An  
Bord  
Pleanála

## Inspector's Report ABP-305345-19

### Strategic Housing Development

Demolition of existing buildings and construction of 287 no. apartments, crèche and associated site works.

BOUNDARY TREATMENT KEY PLAN
SCALE 1: 1000 @ A1

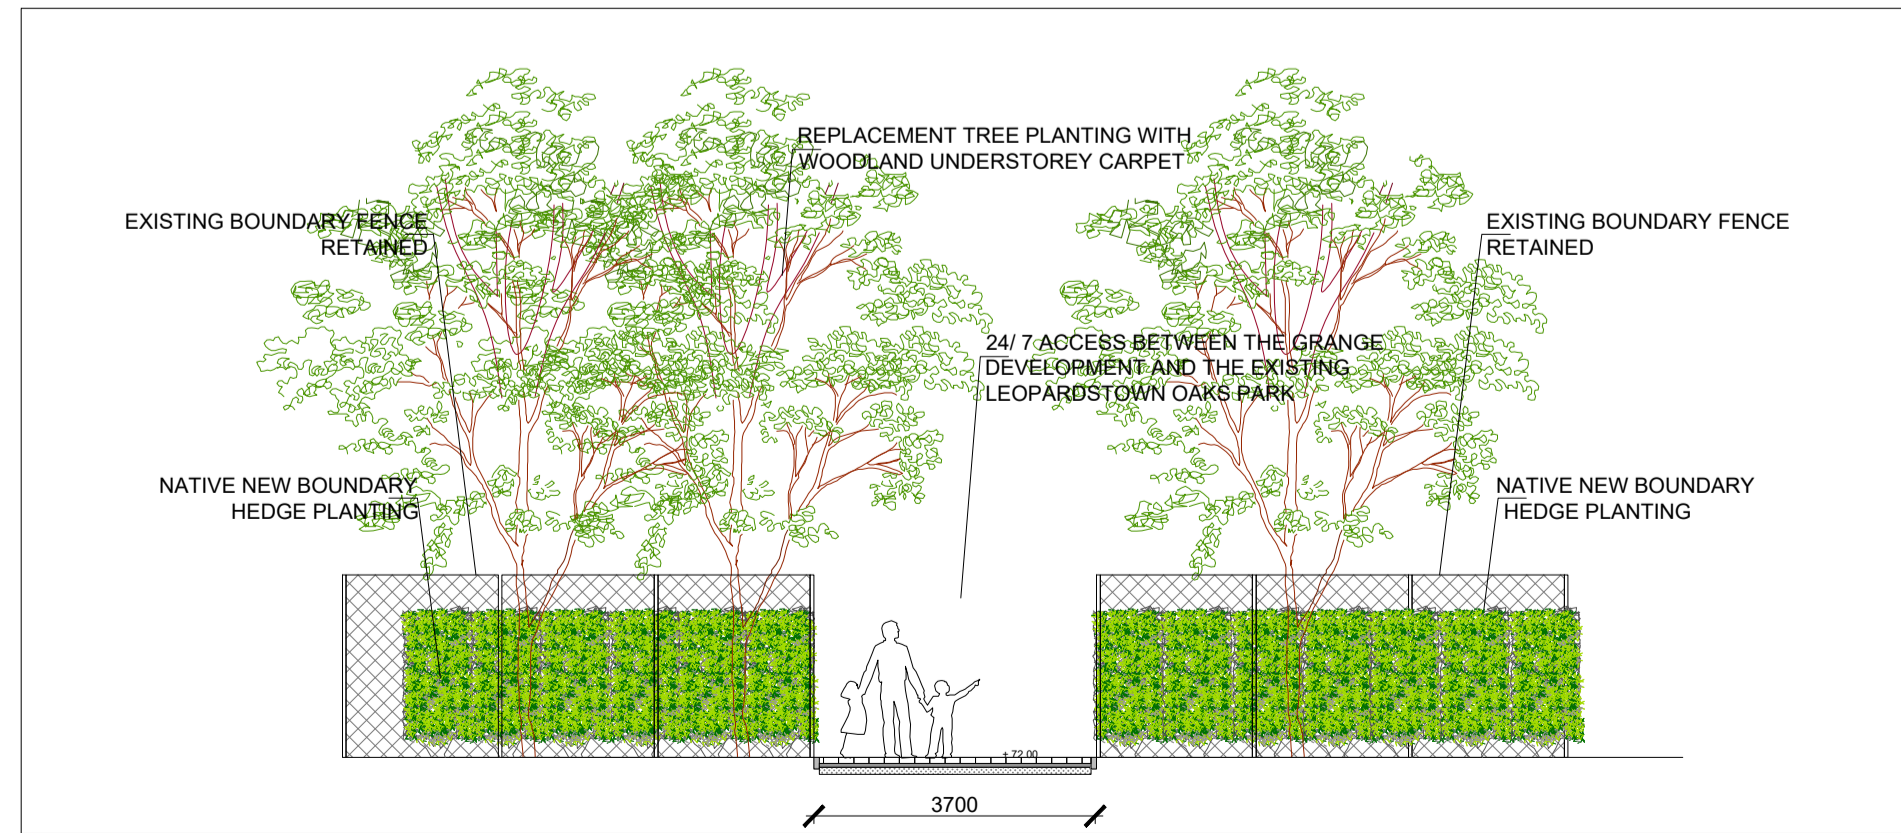
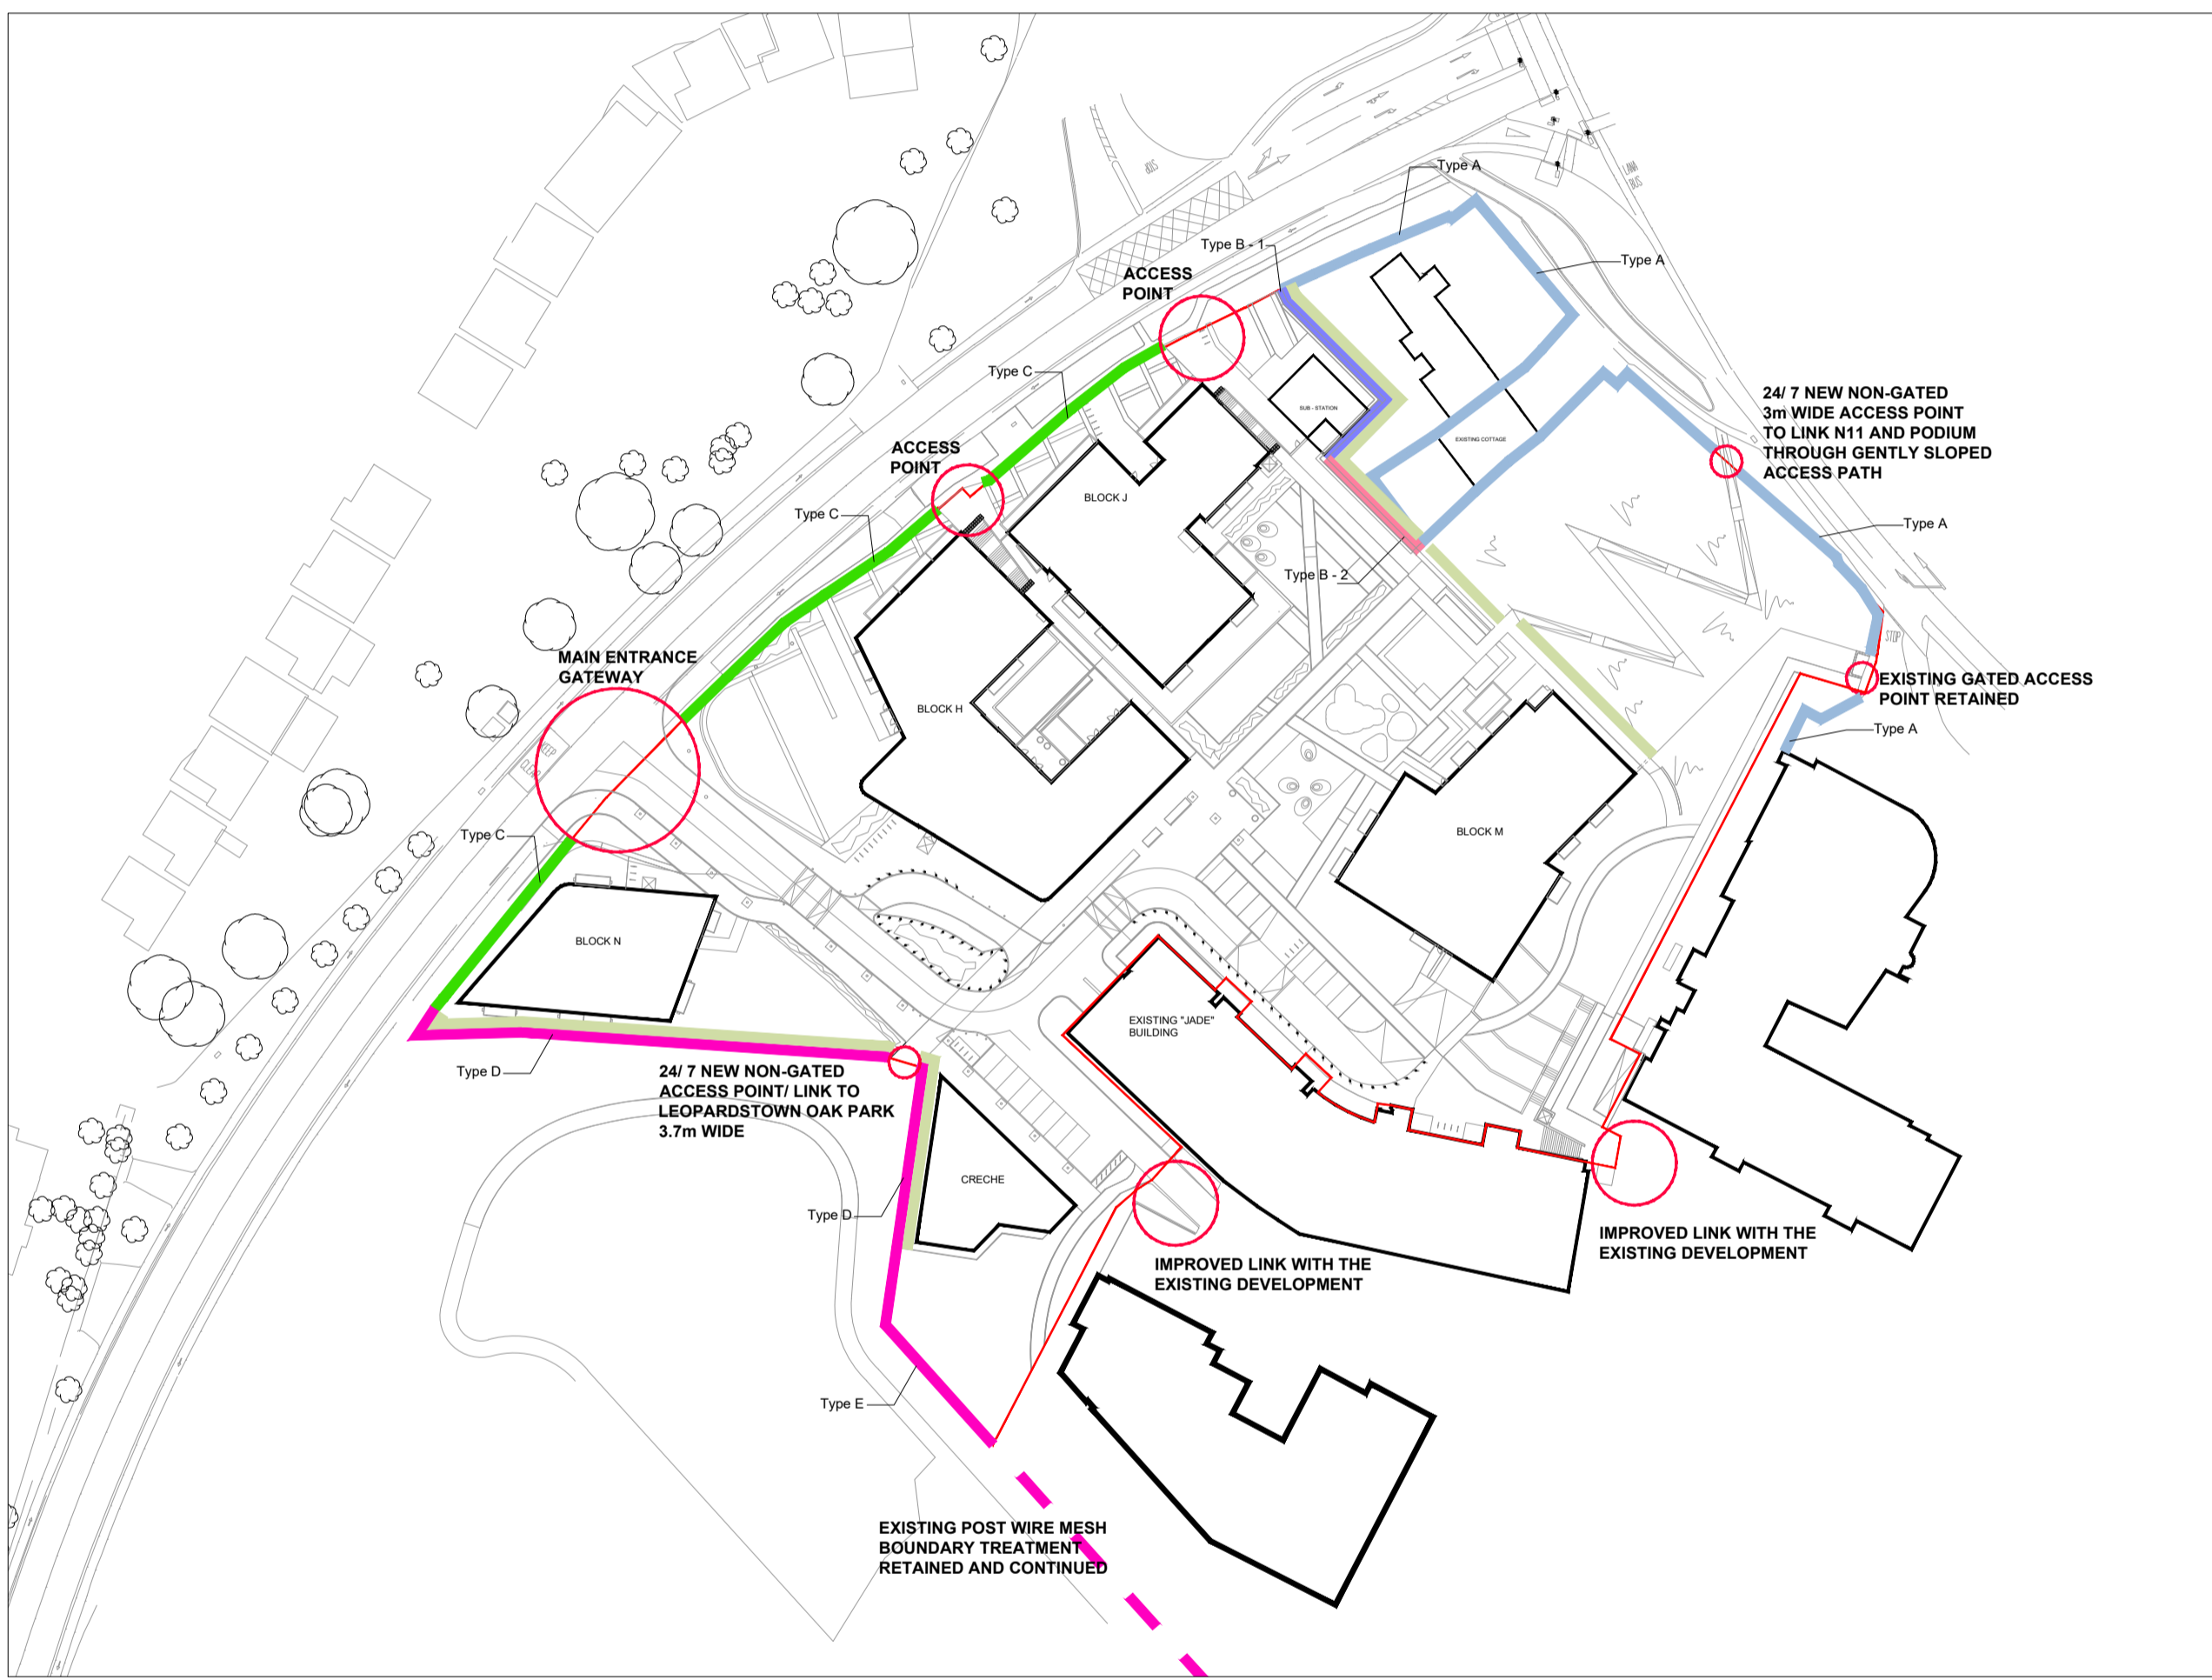
The submitted landscape plans provides details of connectivity and permeability through the site. The PA report notes that the report from the parks section states that the connection into the nearby park with the proposed 'newpath' to the southwest of the site does not have the permission from the current landowners of Leopardstown Oak Park. The applicant's drawings indicate the removal of a fence

and provision of a 3.5m wide connection to the adjacent park. The applicant states they are not in a position to deliver any works outside the redline boundary. The PA raises concerns in relation to the deliverability of this link to the neighbouring area of open space.
